State Environmental Planning Policy (Transport and Infrastructure) 2021
State Significant Development Application - SSD-76555711
3-5 Help Street, Chatswood
Request for additional information

16 July 2025

REF: 8917	CONTOURS: 0.5m
ISSUE: C	DATUM: AHD
SURVEY DATE: 26/08/25	AZIMUTH: MGA2020
SCALE: 1:150	SHEET 1 OF 4 SHEETS

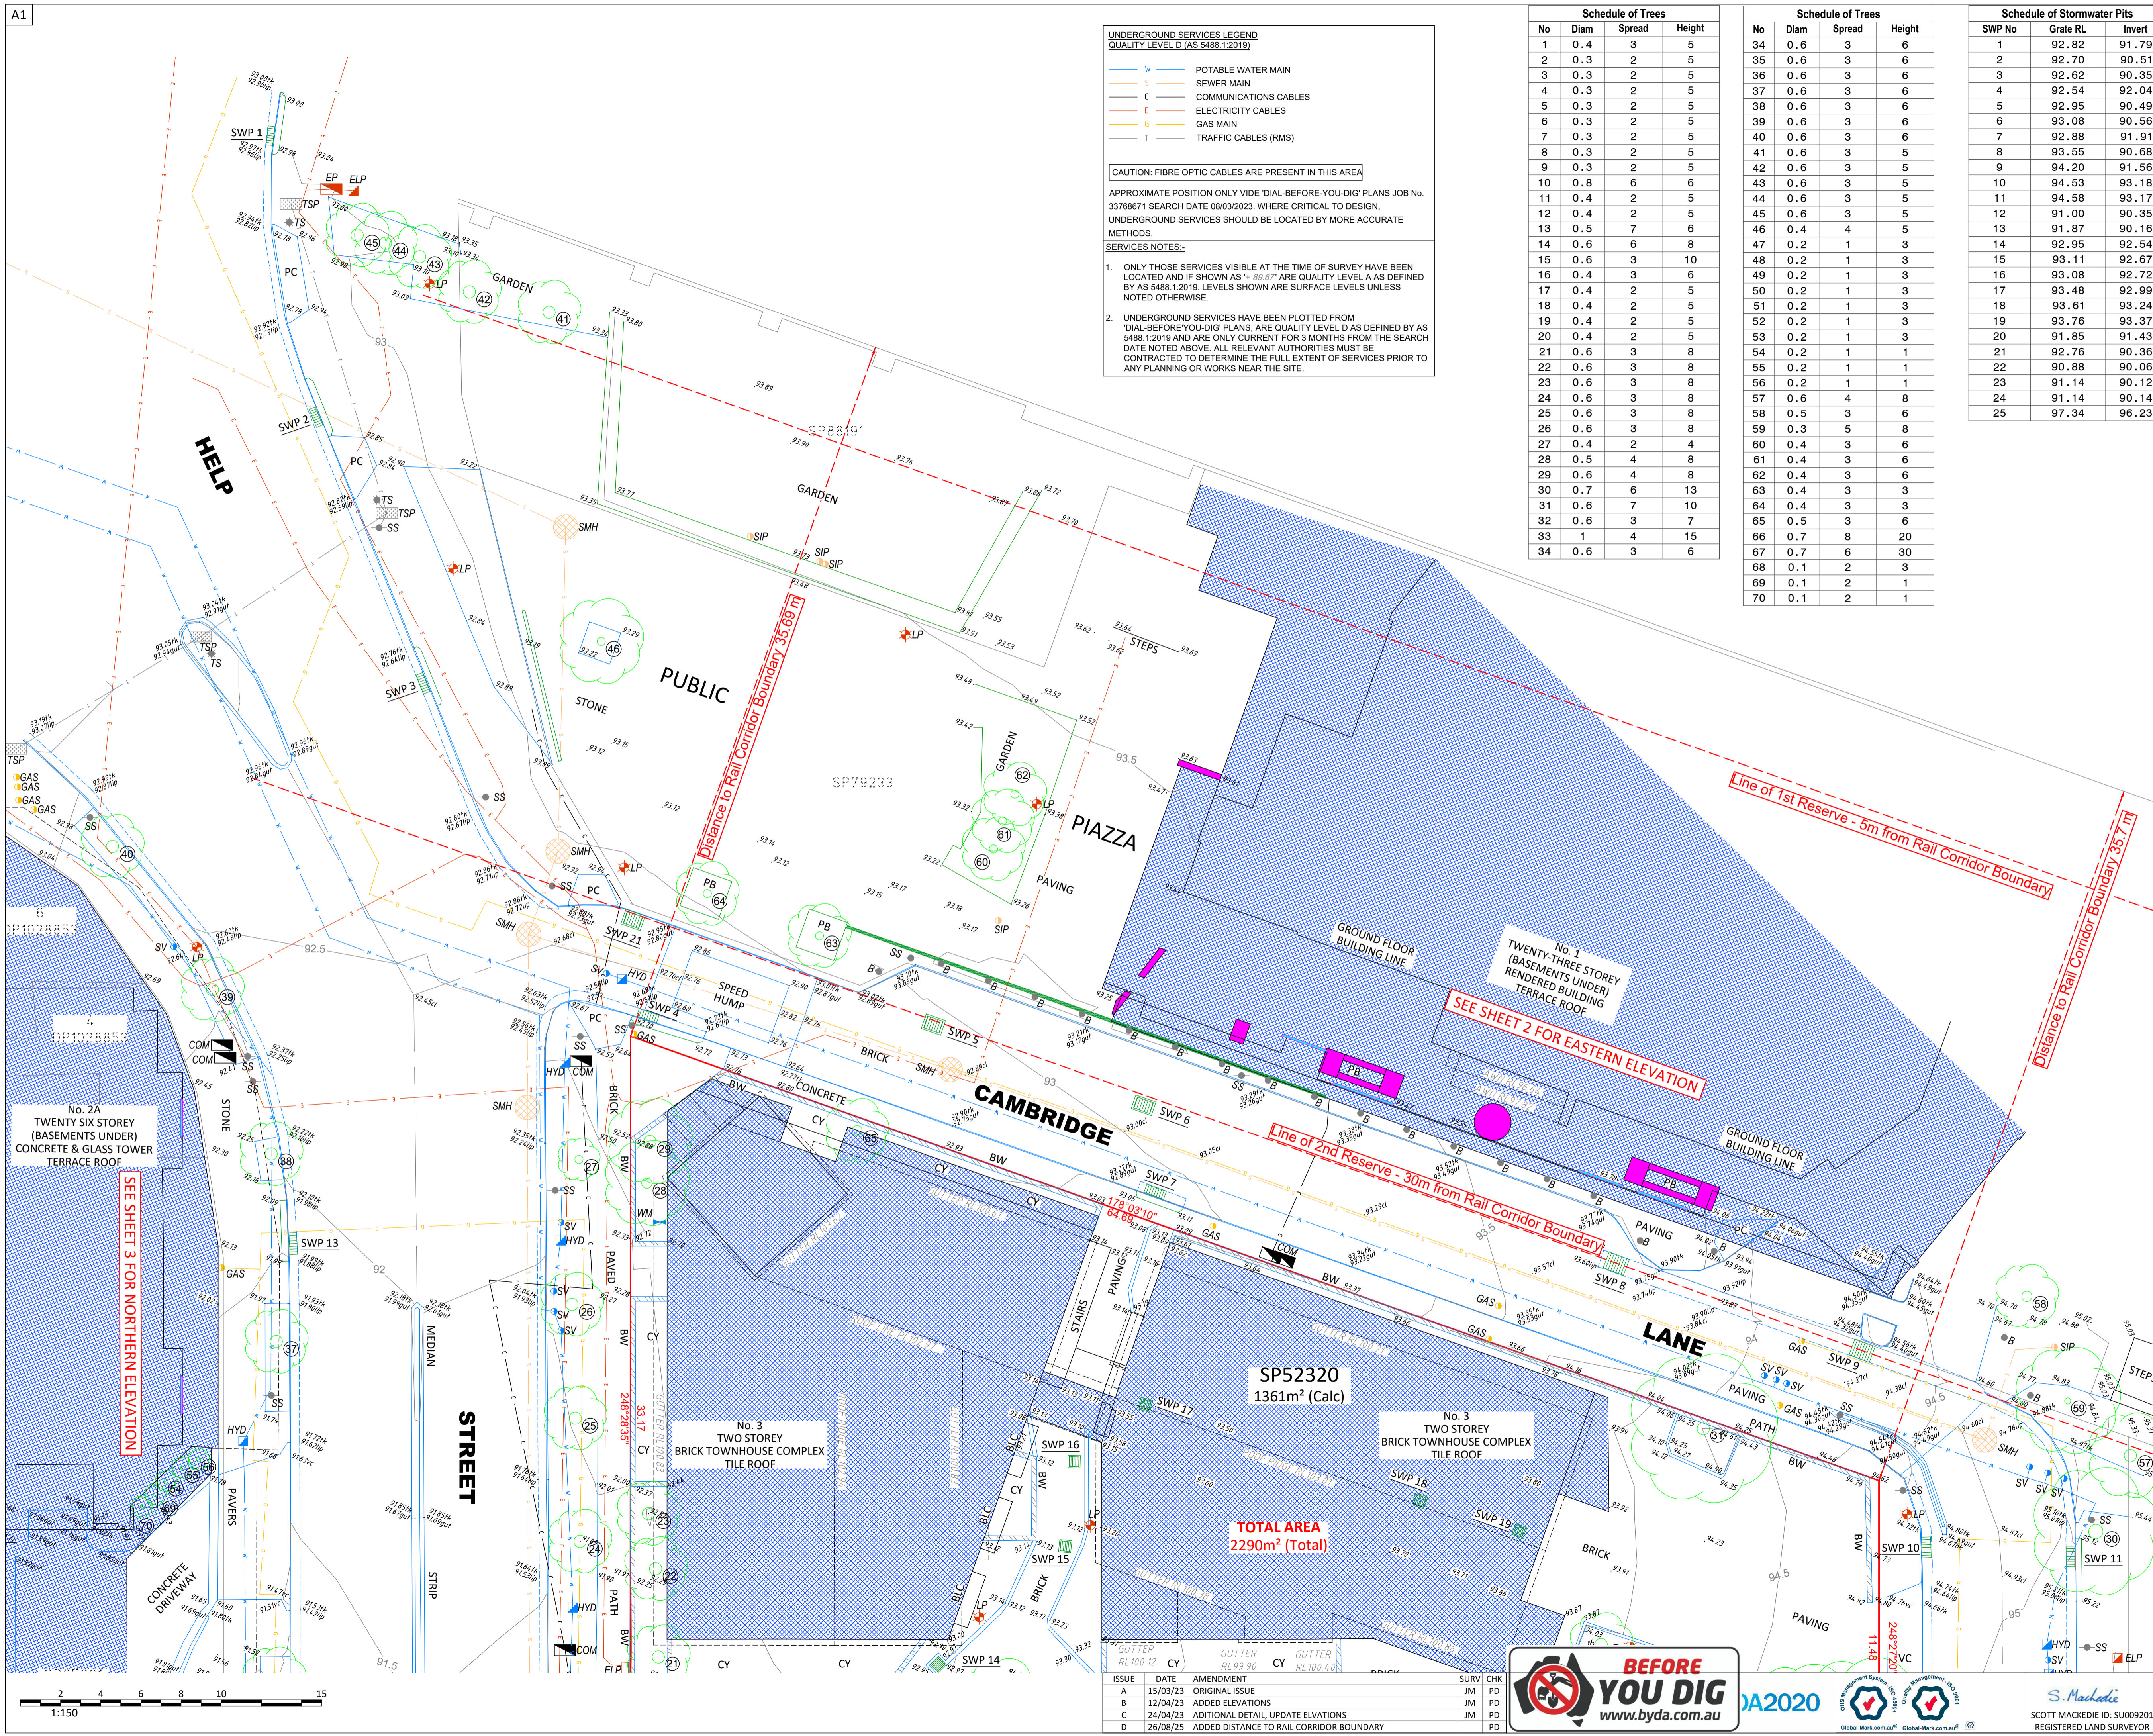
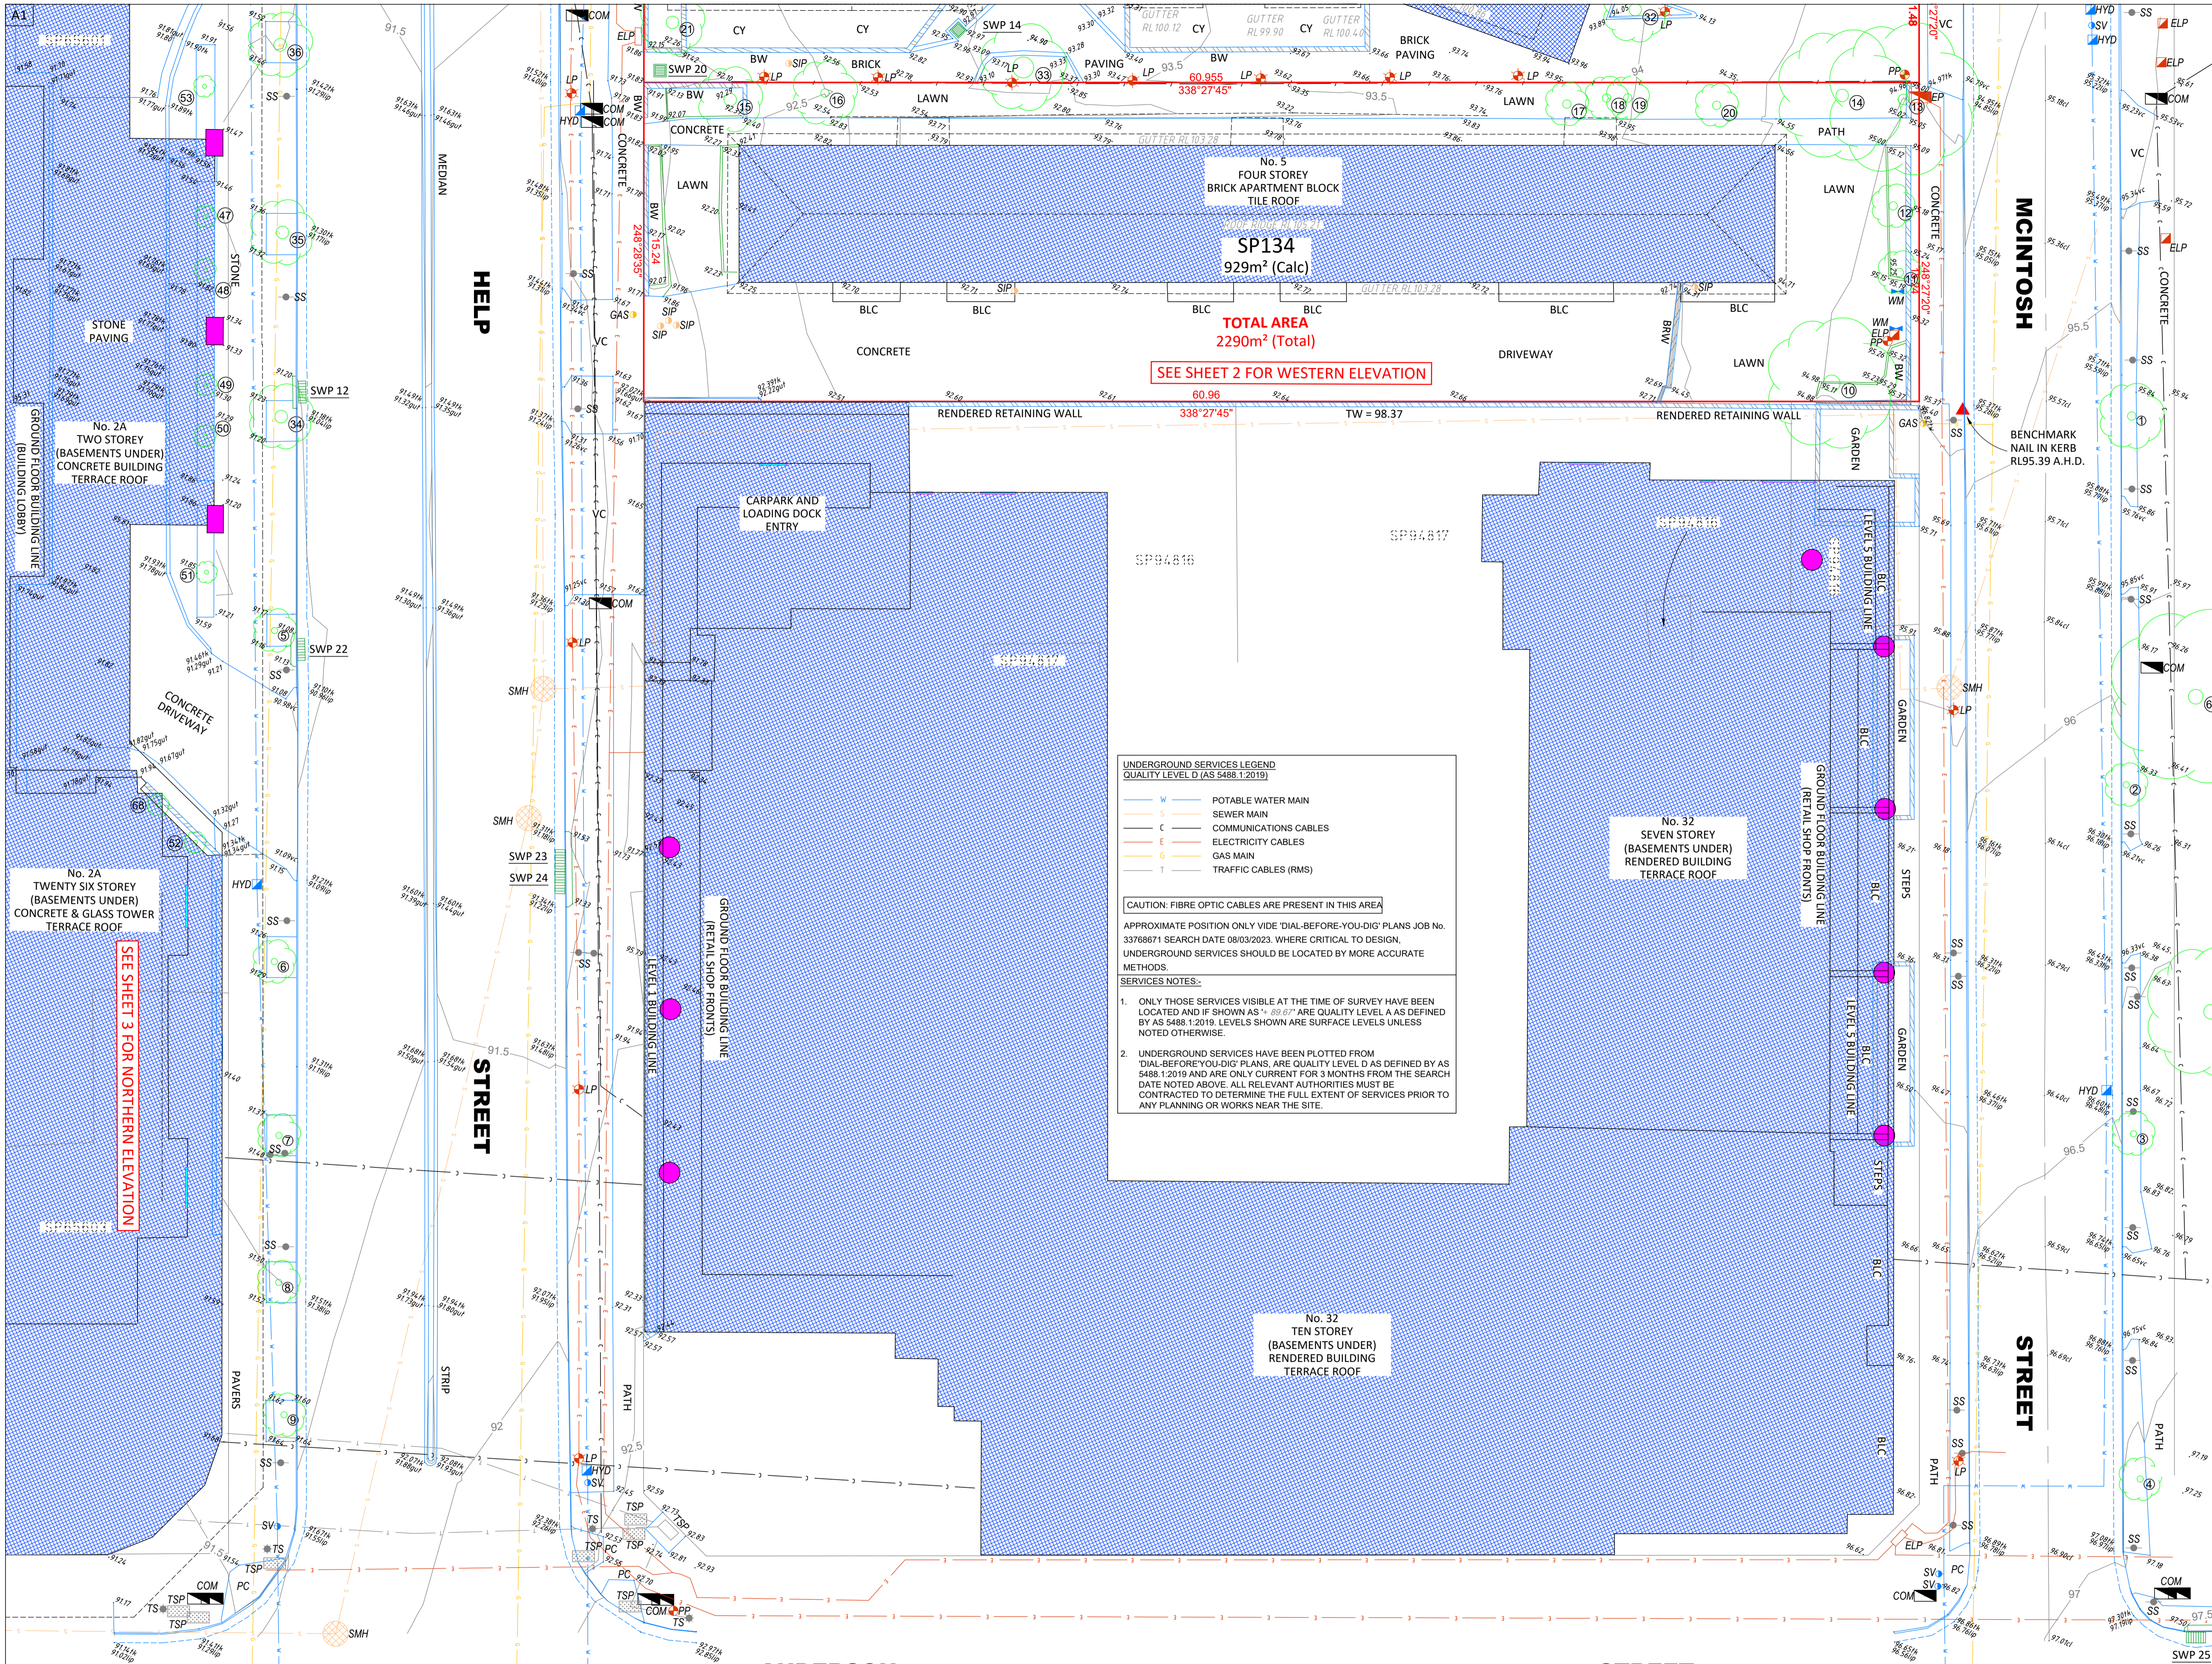
- a) **Survey Plan:** a registered surveyor verified detailed survey information showing the distance of the development to the rail corridor, specifically plan and elevation.
- b) **Ground Anchors:** confirmation of the extents of ground anchors, if required for shoring design.
